Our ref: RA/2015/132060/03-L02
Your ref: EN060004
Our ID: 10031562
Date: 12 October 2015

WRITTEN REPRESENTATION

A REPLACEMENT HIGH-PRESSURE GAS PIPELINE WITHIN A BORED TUNNEL BENEATH THE HUMBER ESTUARY AND ASSOCIATED DEVELOPMENT, INCLUDING A CONNECTING PIPELINE, MINOR MODIFICATIONS TO PAULL ABOVE GROUND INSTALLATION AND ASSOCIATED TEMPORARY LAY DOWN, WORKING AND MITIGATION AREAS. FROM PAULL, EAST RIDING OF YORKSHIRE TO GOXHILL, NORTH LINCOLNSHIRE.

RIVER HUMBER GAS PIPELINE REPLACEMENT PROJECT		
INDICATIVE PAULL SITE LAYOUT FIGURE 2.4 B		
REFERENCE		
DRAWN	CHECKED	APPROVED
JN	KB	NH
SCALE	ORIG SIZE	SHEET
1 : 1000	A1	1 of 1
DATE		REVISION
12 OCT 15		03

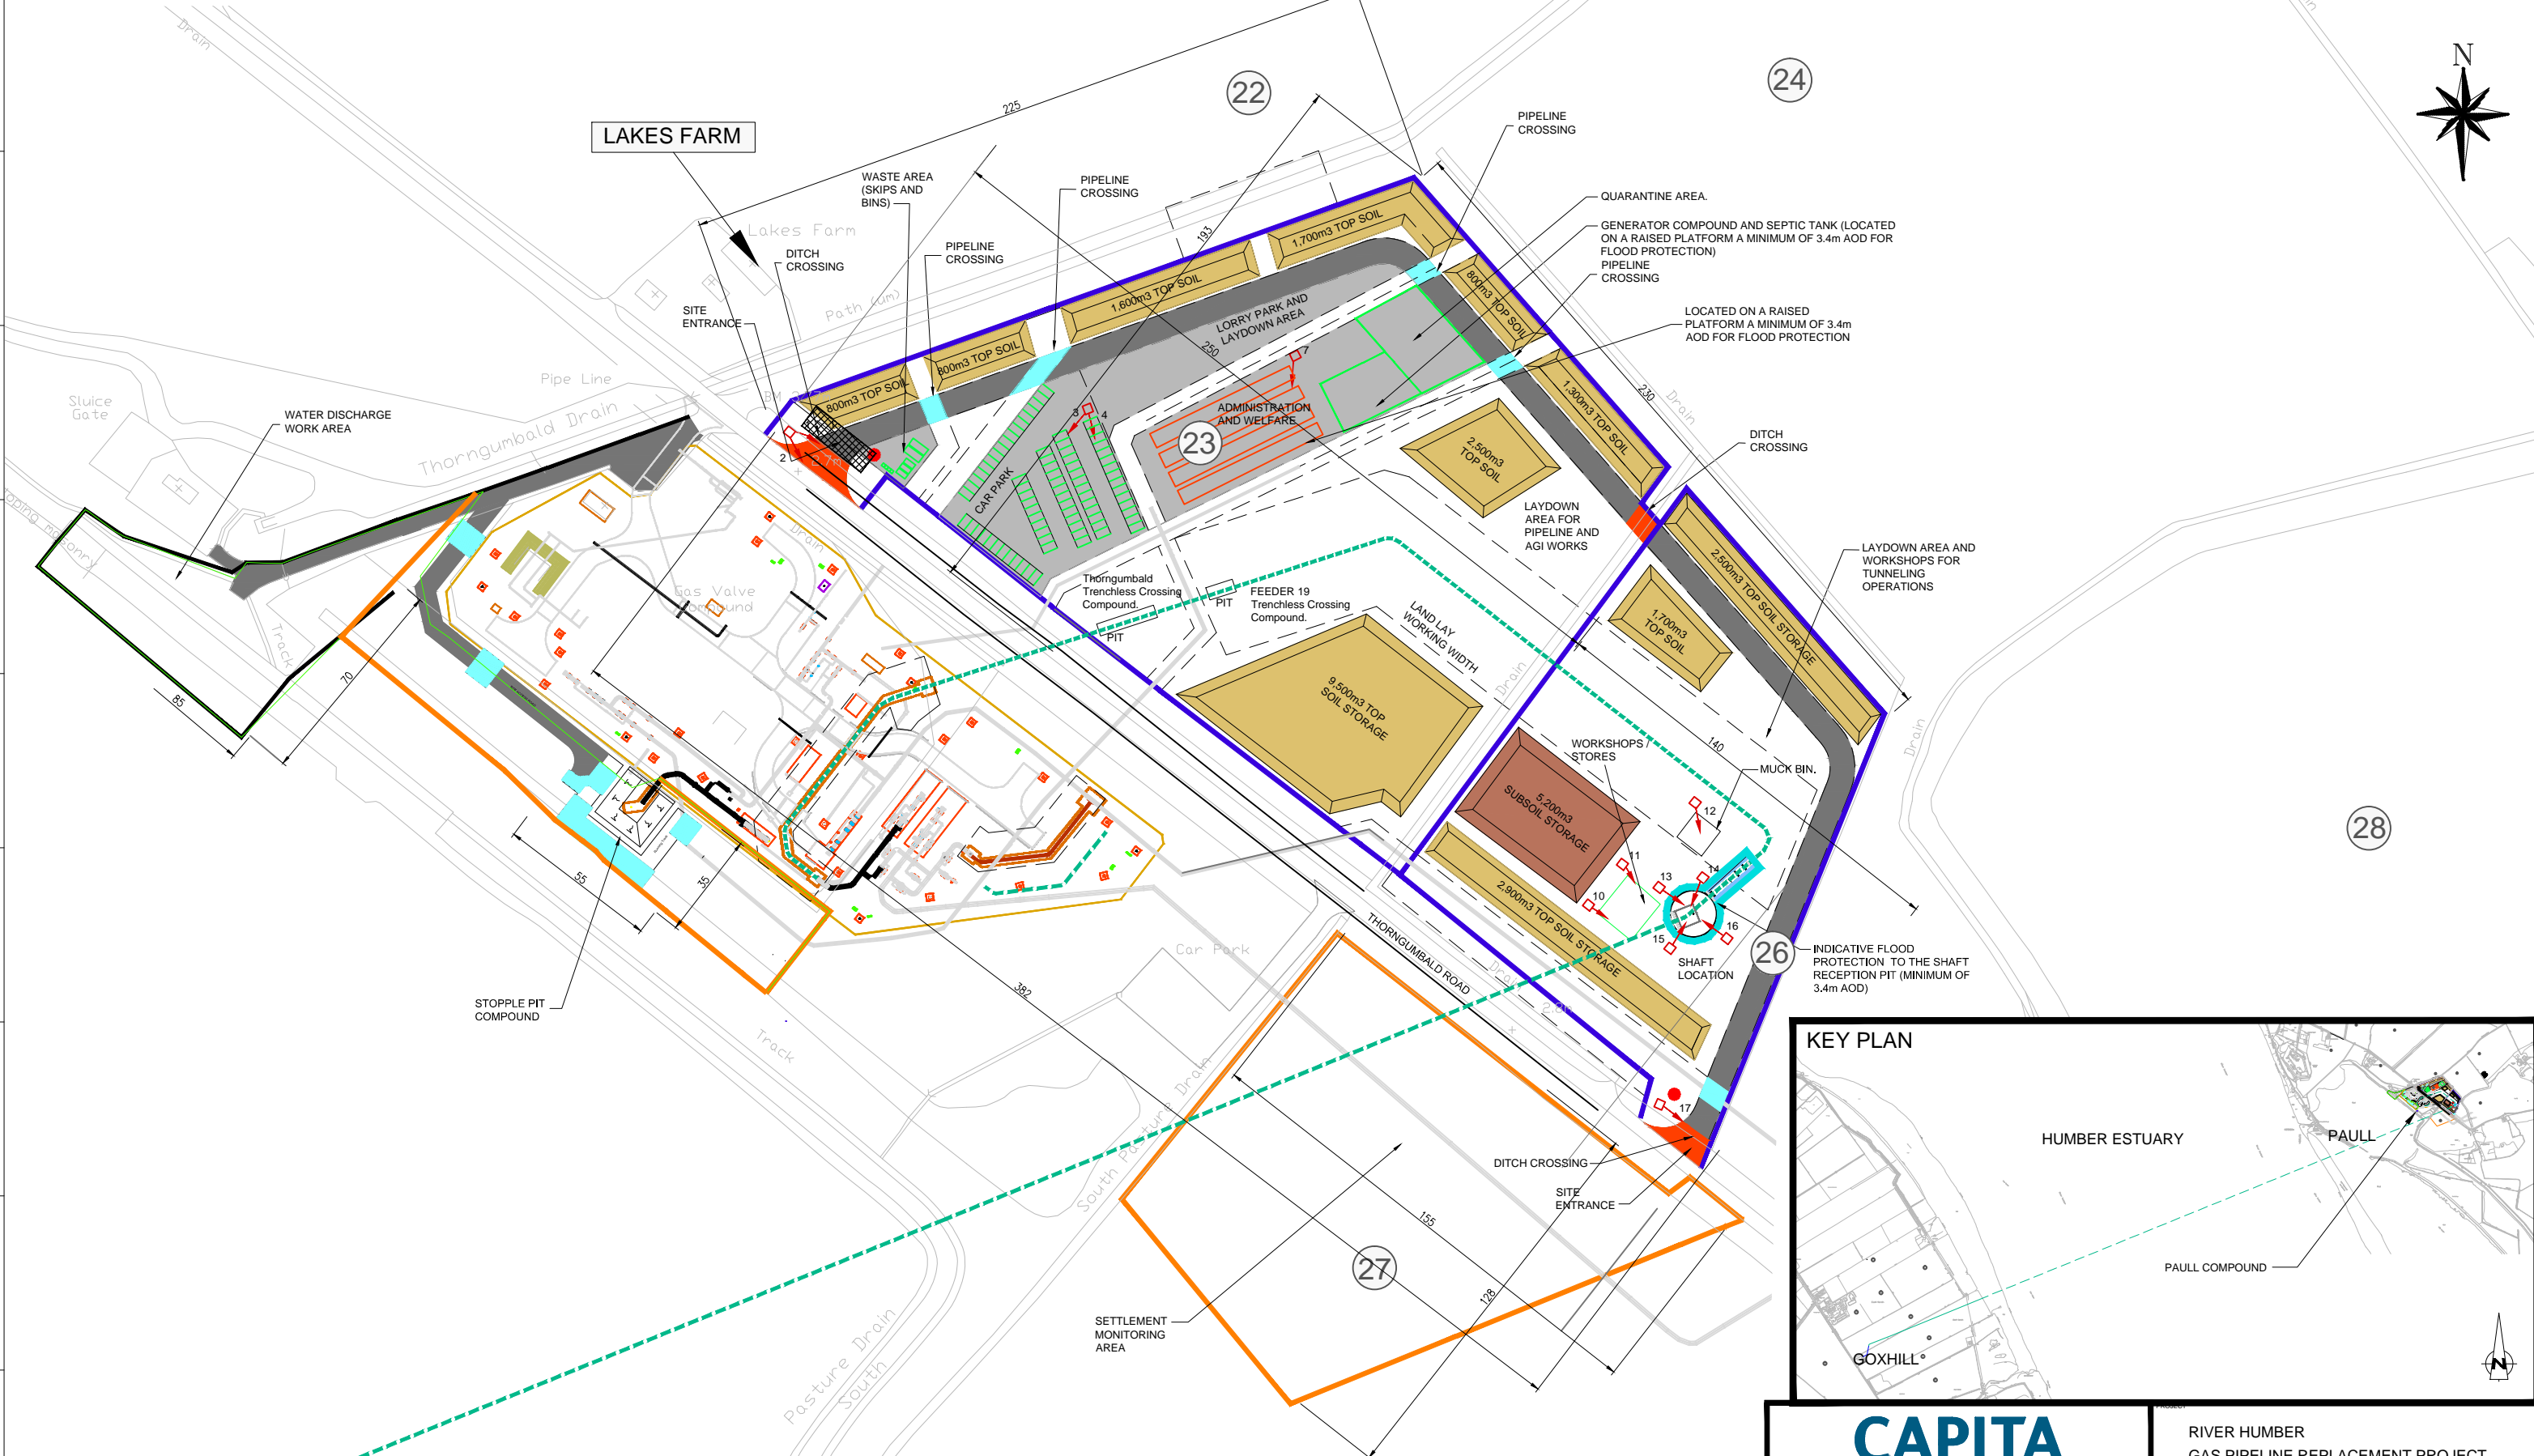
- 8) The 'Indicative Paull Site Layout' shows an area denoted as the 'water discharge work area' which appears to coincide with the existing flood defence and Thorngumbald Pumping Station outfall. More detail is requested to assess any potential impacts. This was discussed with the applicant at a site meeting, but additional information has not yet been forthcoming;

9.3 The flood bunds mentioned in Section 6.1.5 of the FRA are not shown on Indicative Goxhill and Paull Site Layout drawings. Given the detail and complexity of these drawings which show fencing, spoil bunds and the like, we would expect the flood bunds to have been included. This drawing should be updated to include the bunds so that their relationship with other site features can be seen.

9.8 In addition, the Scheme Description Figure 2.3 'Indicative Paull Site Layout' shows an area denoted as the 'water discharge work area', which appears to coincide with the existing flood defences and Thorngumbald pumping station outfall. There is no explanation of the nature and purpose of this area in the accompanying text or any assessment of potential interactions with this existing infrastructure. Additional explanation is needed to understand the impacts on the flood defence/outfall and Paull Holme Strays designated area.
